COMMENTS

CBL: 299-E-026
 permit: 000224

Inspection Record

RIGHT ELEVATION

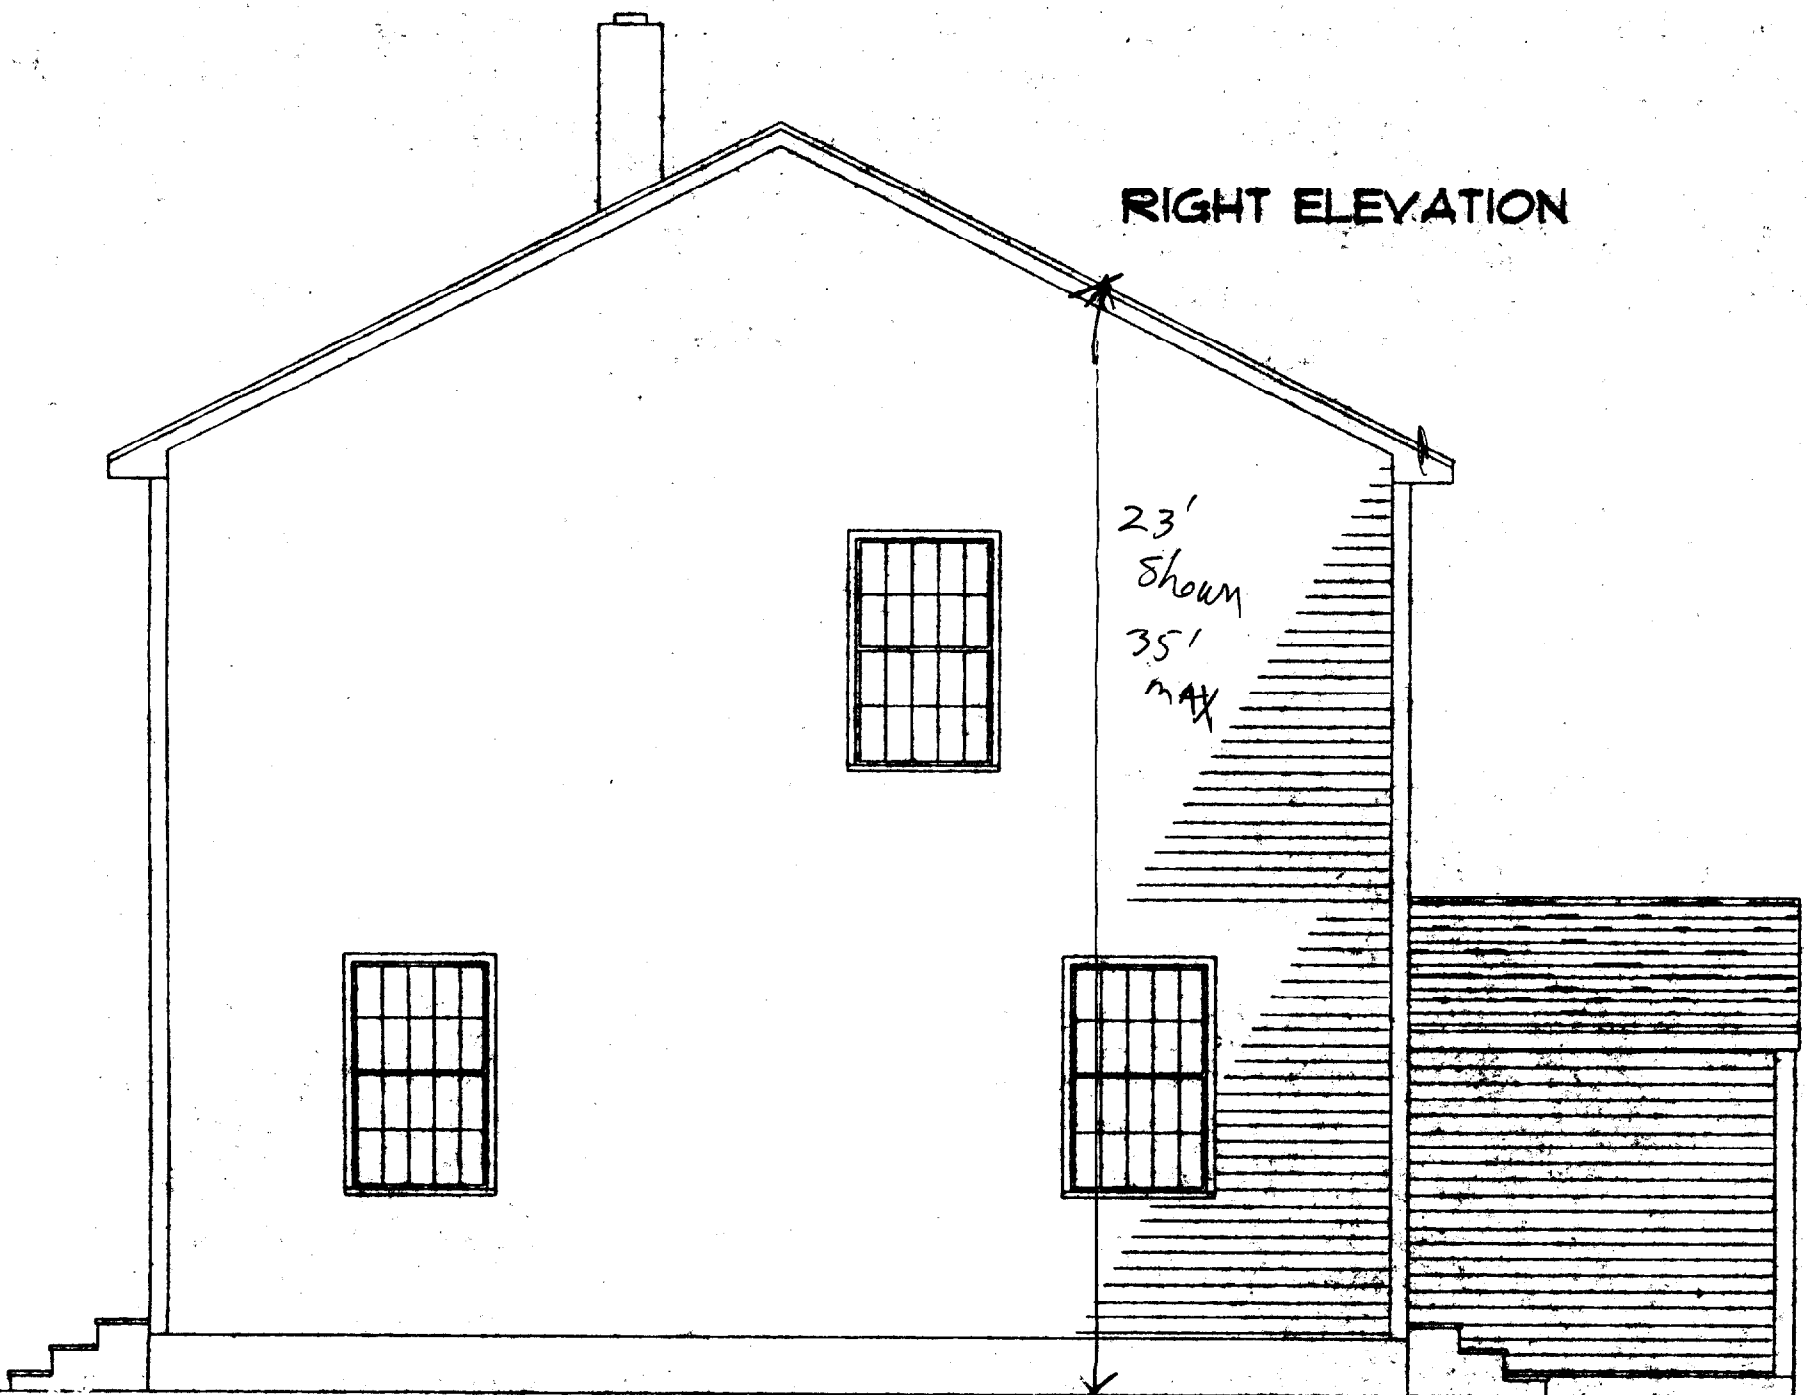
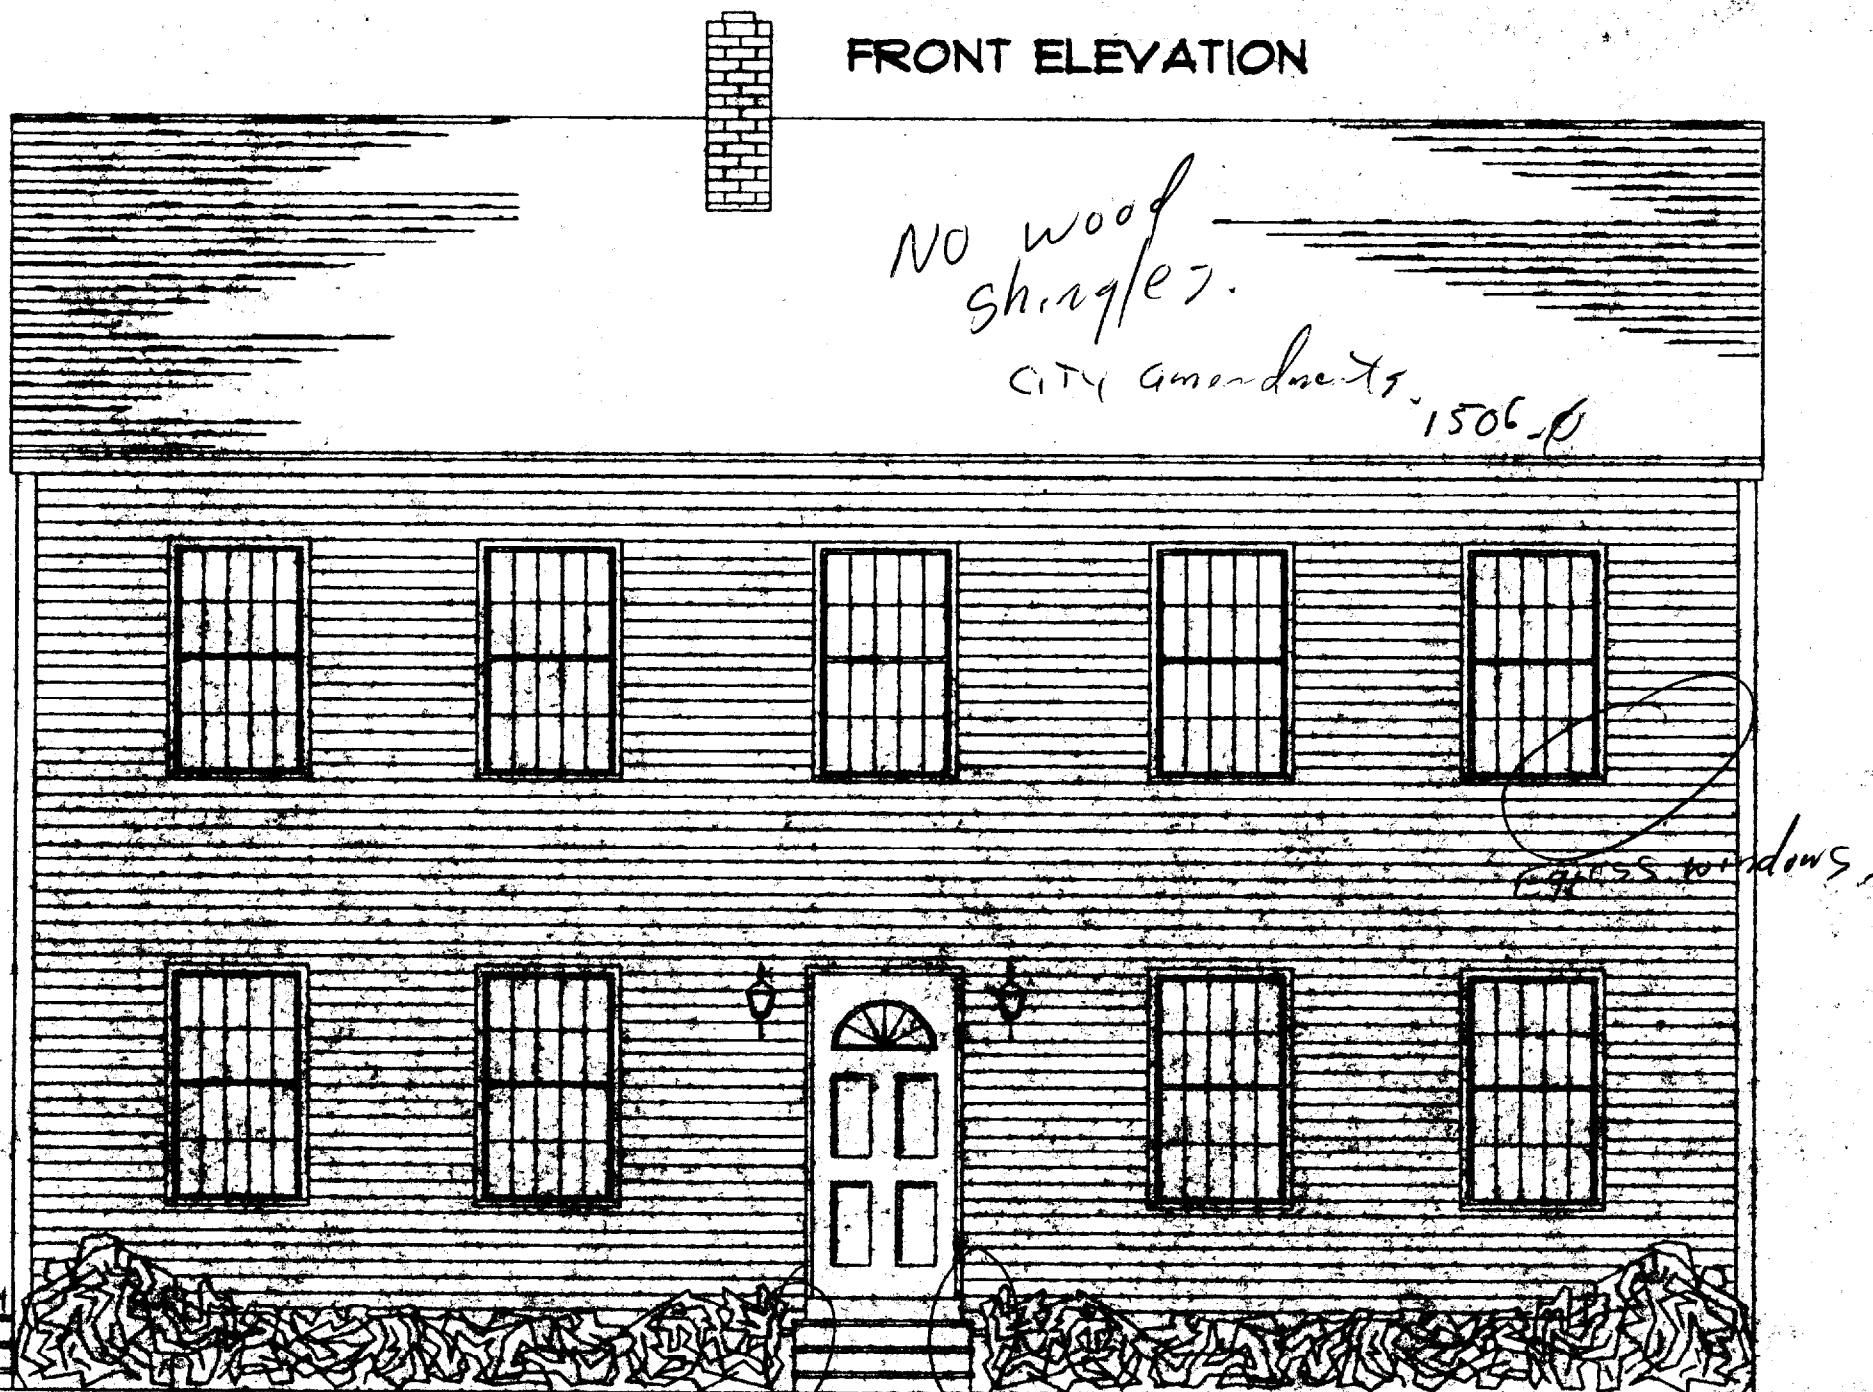
4-6-00 pre construction phone call ~~for~~ with Keith Aiting all pertinent code issues - will fax new Guardrail/handrail code. JB

5-11-00 met w/Eddie Roy regarding stair construction & handrail/guardrail - will be ready for close-in tomorrow JB
